Your Ref: OWPC16714
Our Ref: FP/268/17/PL 26-10-2017
Please ask for:
Richard Temple

Detached 9No. bedroom annexe for Beachcroft Hotel with 9No. car parking spaces.
Boat Pound between Greenock Villa & The Gunpoint Clyde Road Felpham

Thank you for your internet representation made on 21st December 2017 which has been recorded as '**an objection**' with the comments as follows:

PROJECT Gull Point Suites - On the Beach
TITLE Typical Sections
SCALE 1 : 100
DATE 20/09/17
DRG NO IBA/480/09
REVISIONS

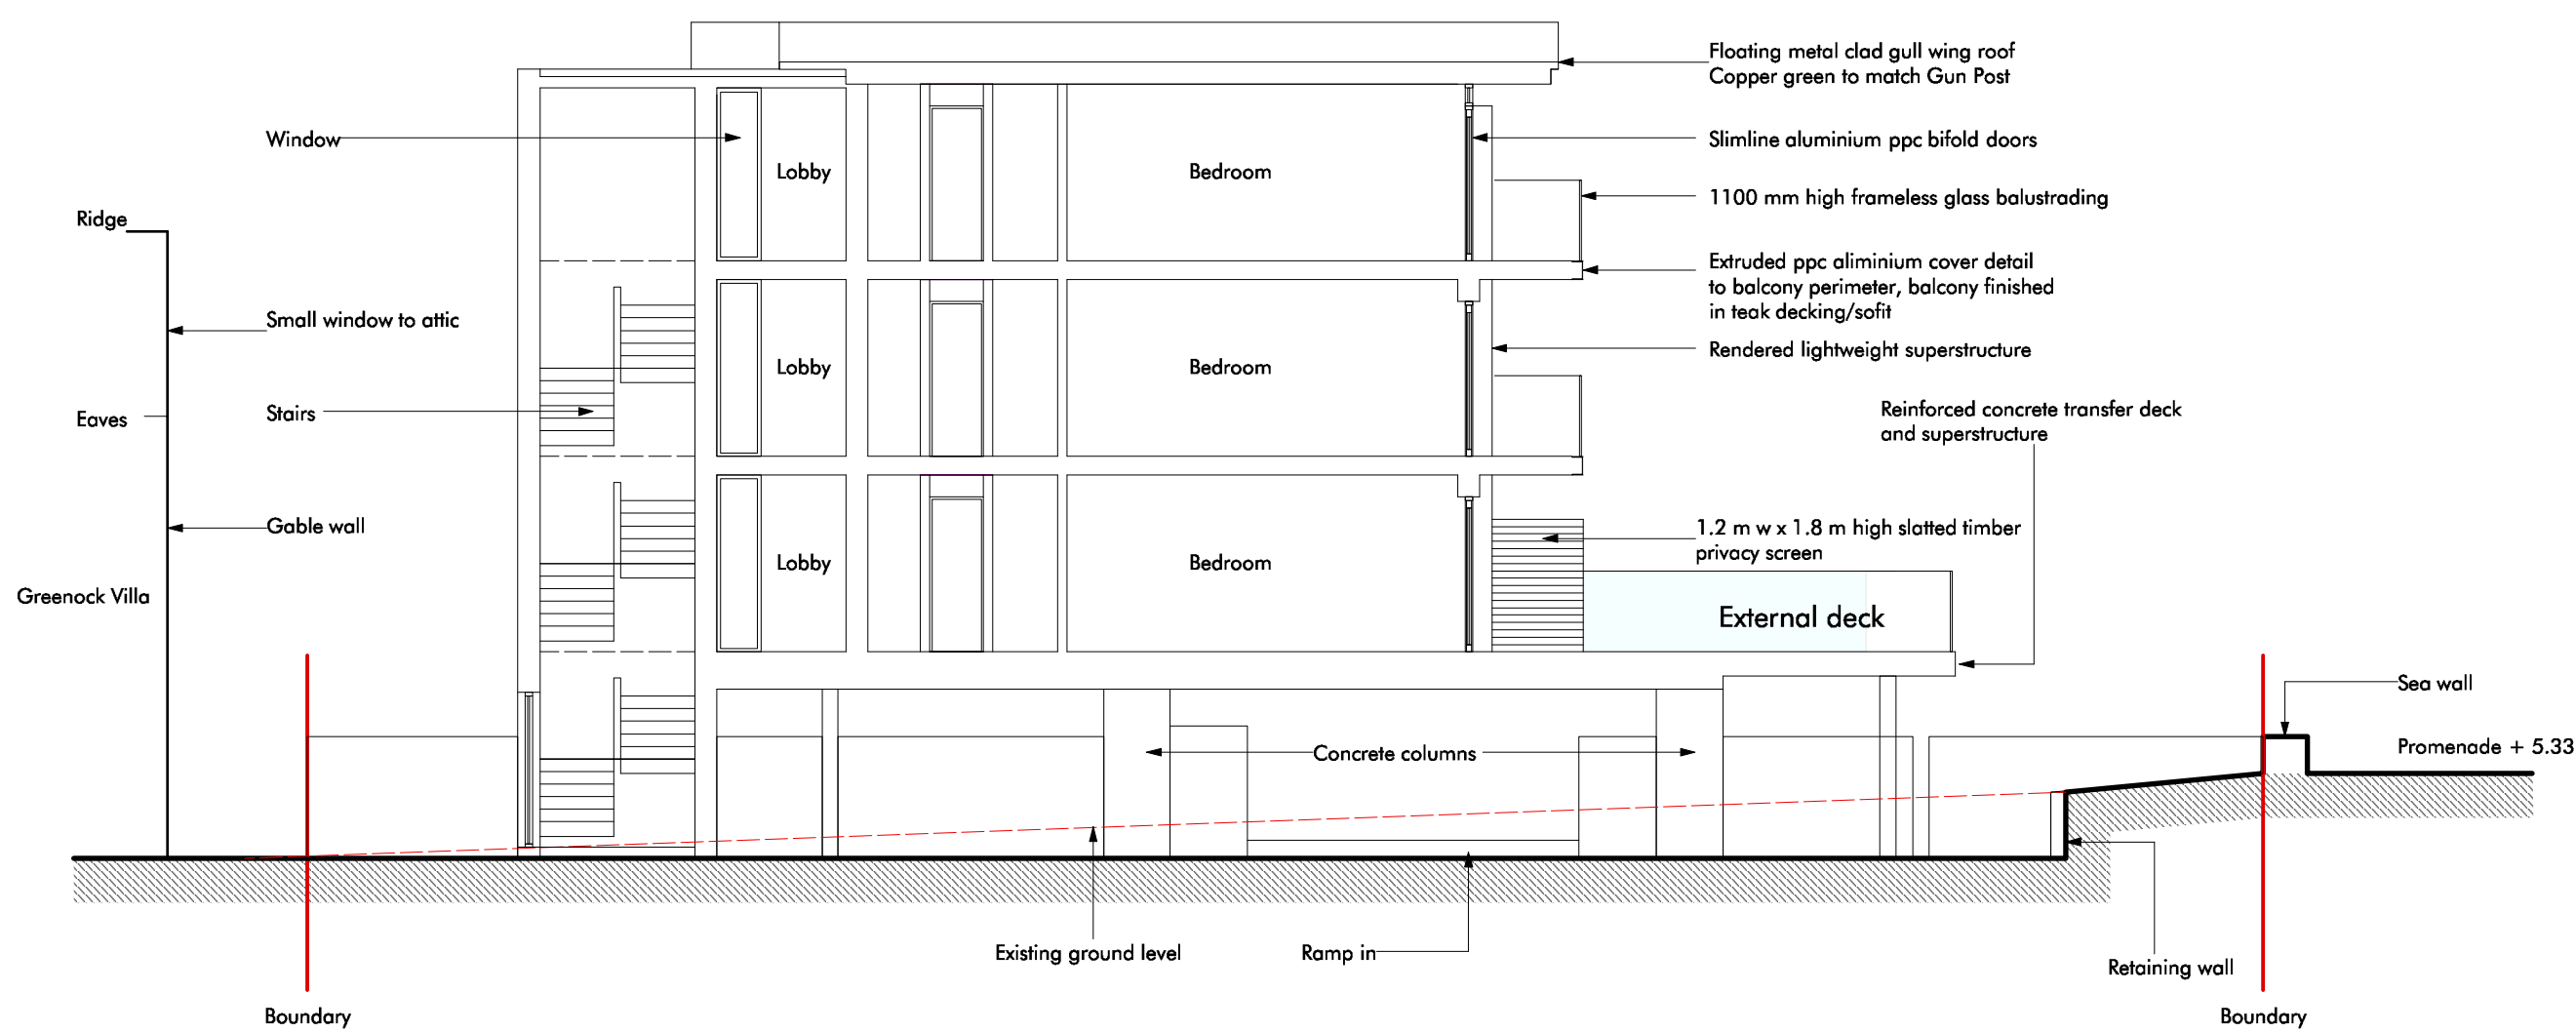
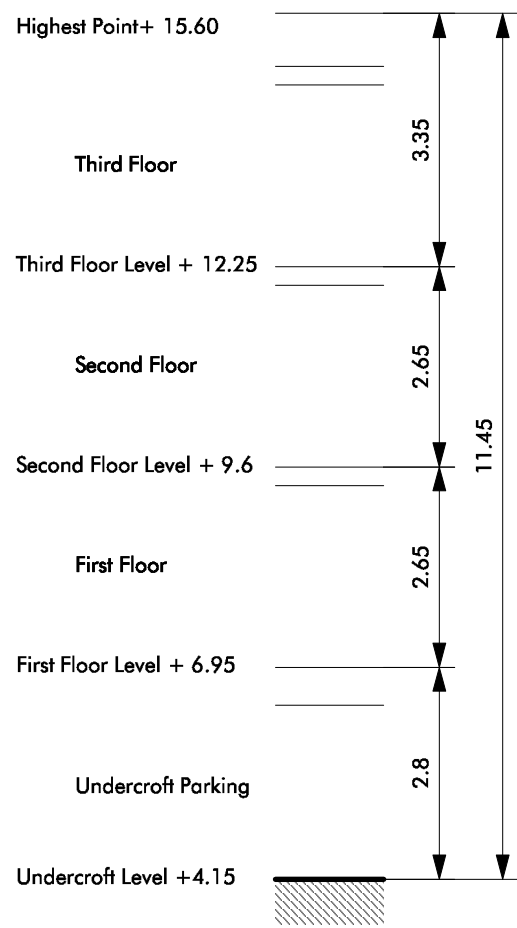
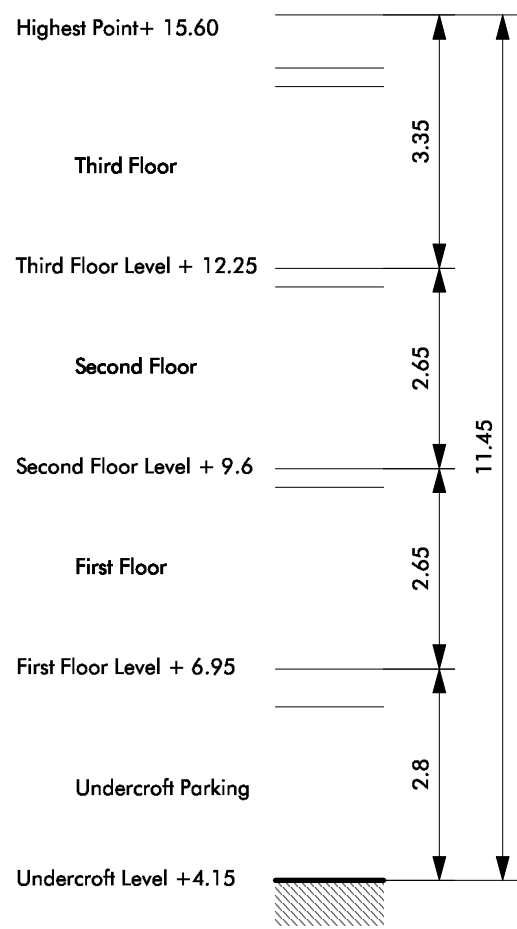
The design in its current form is too dominant on the promenade and dwarfs neighbouring properties. The height of the development should not exceed that of the adjacent property, The Old Gun Post, called The Gunpoint in the application. Such a tall construction would cause difficulties with groundworks given the local water table level.
